Our Ref T22- 000
Your Ref: 20032138 Rep 119/Rep 120
3 April 2023

A66 Trans-Pennine Project Scheme 0102 – M6 Junction 40 to Kemplay Bank

I write further to the Hearings of 1 March and 2 March 2023 and the Applicant's Response to Relevant Representations Part 3, page 403/404 - Document 6.5, the Applicant's Response to Written Representations made by Affected Persons at Deadline 1 - Rev 1 submitted at Deadline 2 (document 7.6), Applicant's Responses to the Examining Authority's Written Questions (document 7.240 and the A66 Northern Trans-Pennine Project Applicant's Response to Deadline 3 Submissions (Document 7.27) on behalf of Penrith Properties Limited, BVI registered company 249033, (PPL) and in relation to Post Hearing submissions of 13 March 2023 in respect of the proposed compulsory acquisition of land at Ghyll Mount, Gillian Way Penrith, identified in Developer's Application Document 5.13 as Plot 0102-01-20.

Drawing Number	Project	Originator	Volume
HE565627	- AMY	- HAC	-
S0102	- DR	- YL	- 000002
Location	Type	Role	Number

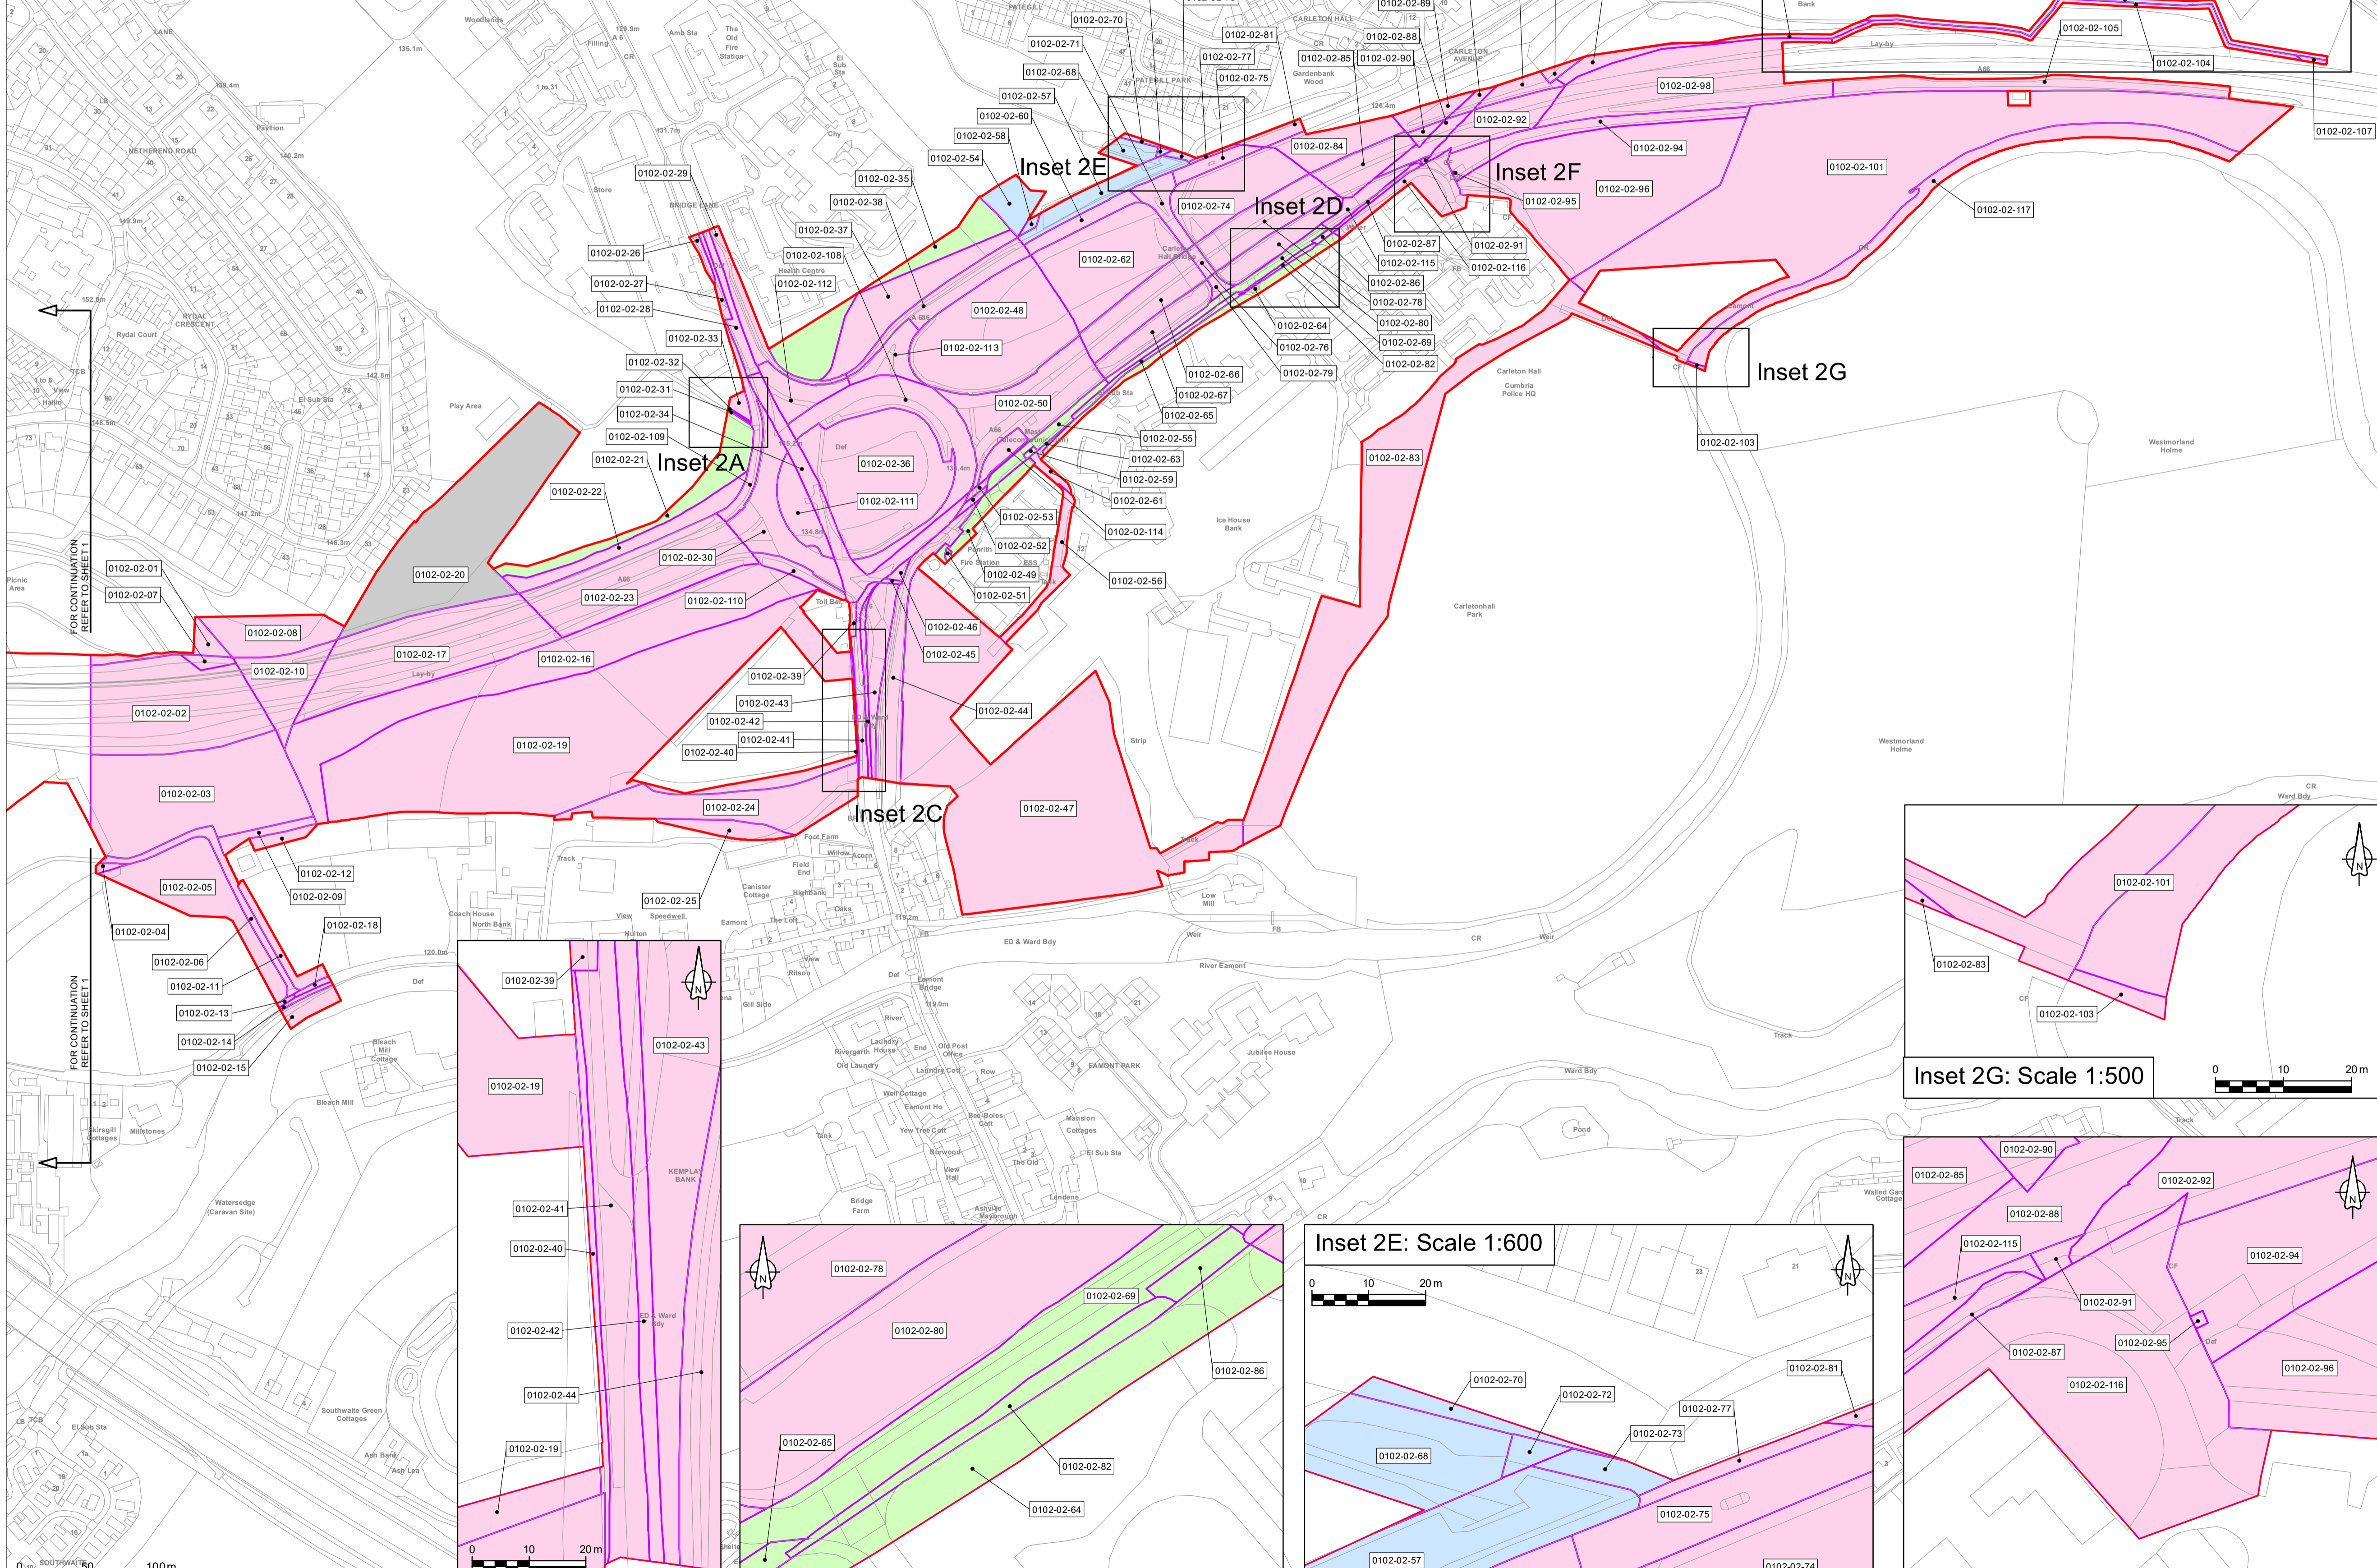
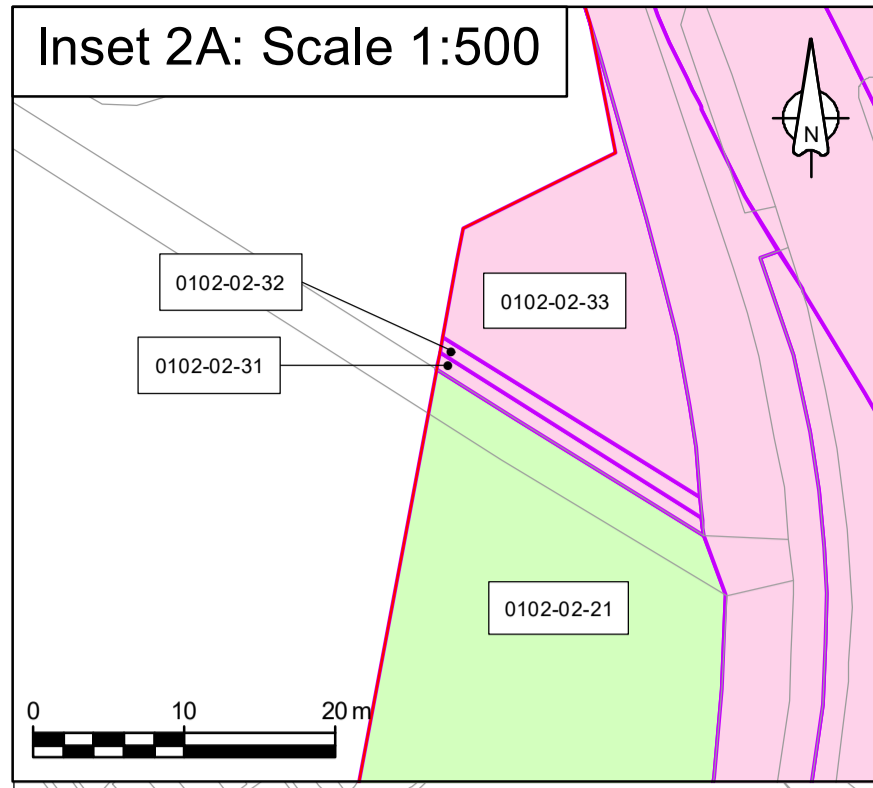
There is no justification in the information provided to compulsory acquire Plot 0102-01-20 and the information provided to support the acquisition of this plot is either erroneous, mistaken or not provided.

No land from plot 0102-01-20 is required for the removal of existing vegetation on the PPL land or to enable additional planting to take place in the context of the Applicant's road safety standards that maintain distance of planting from the proposed road.

Drawing Number	Project	Originator	Volume
HE565627	- AMY	- HAC	-
S0102	-DR	-CH	-000002
Location		Type	Role Number

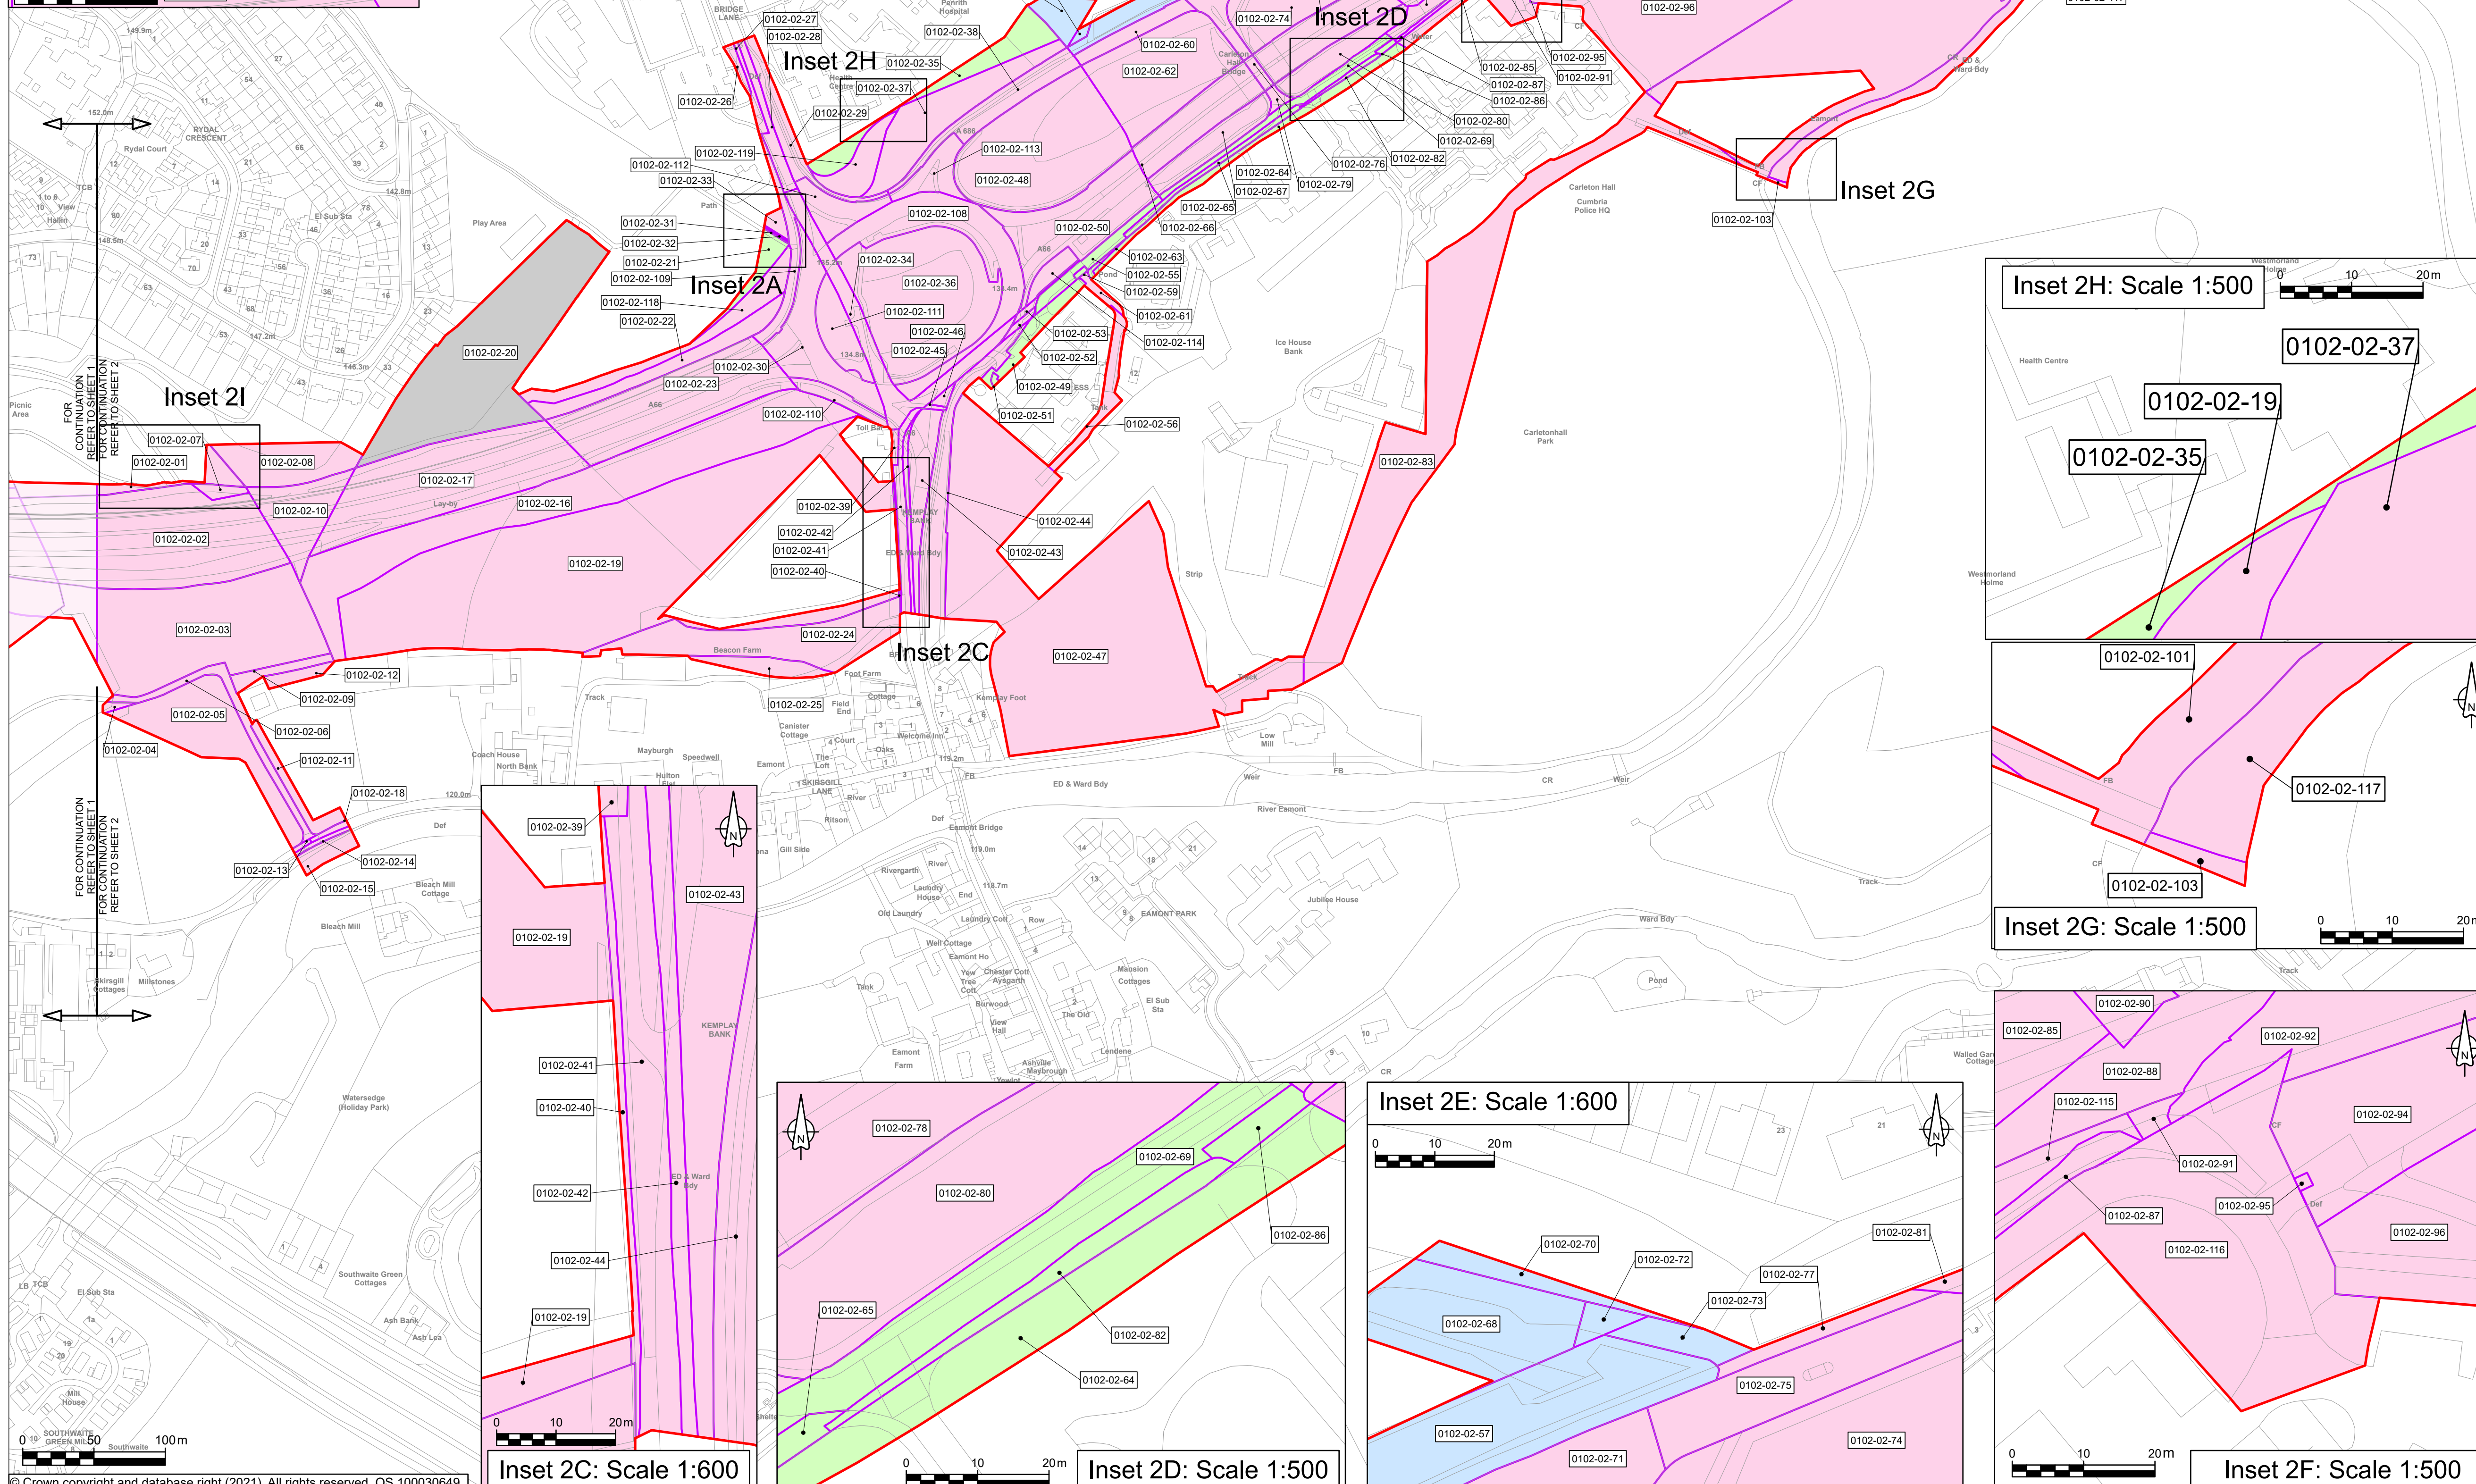
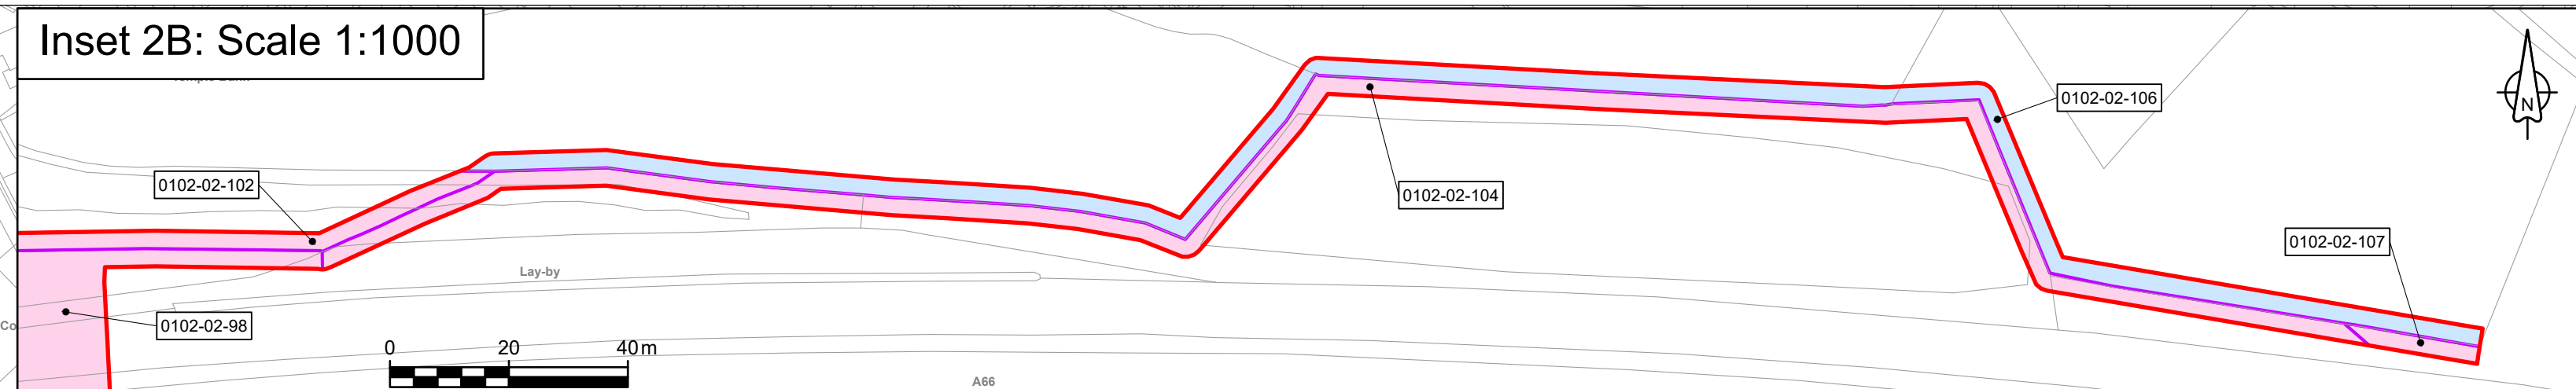
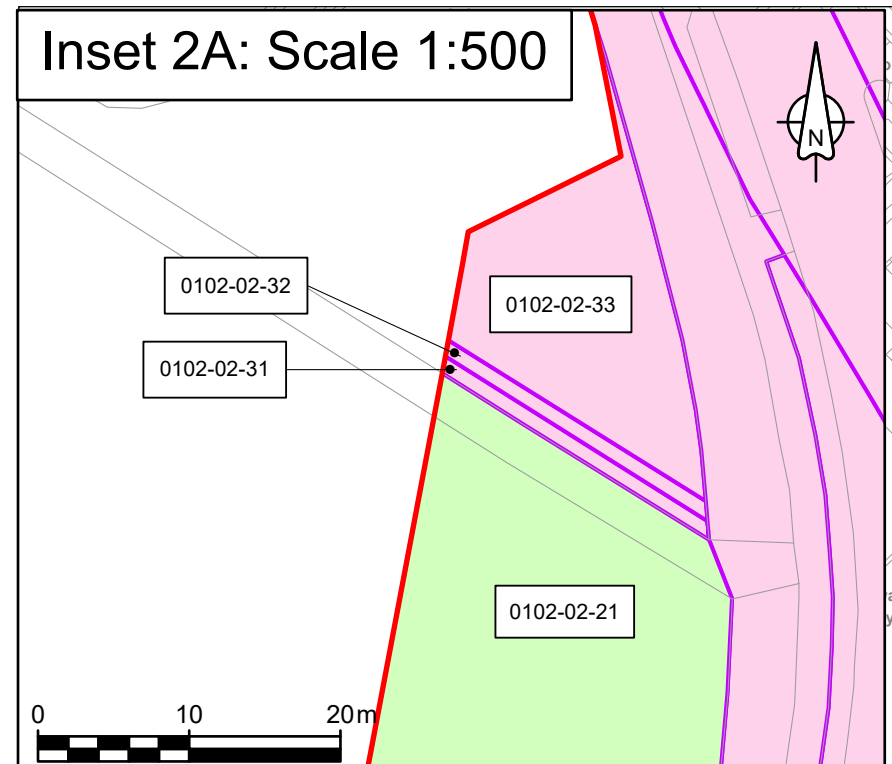
- 1 The applicant has stated that the land at the southern end of PPL land holding may be needed to accommodate minor changes in level associated with adjoining carriageway works to plot 0102-01-20 – works packages 0102-3, 0102-1B and 0102-4.

- c) Assuming the levels are as presented in Doc 5.17, the least change for works on the A592 (0102-4) are 0m (0 mm) and the greatest 0.390 m (390 mm) the existing verge width with the National Highways ownership is between 11 metres and 20 metres to kerb of carriageway within which to accommodate any levels change before land within plot 0102-01-20 is required. There is no need to acquire additional land to accommodate levels changes.

As demonstrated in document 7.30 Appendix G the available land within National Highways existing ownership adjoining 0101-01-20 is sufficient to accommodate the non-motorised user facilities without requiring additional land.
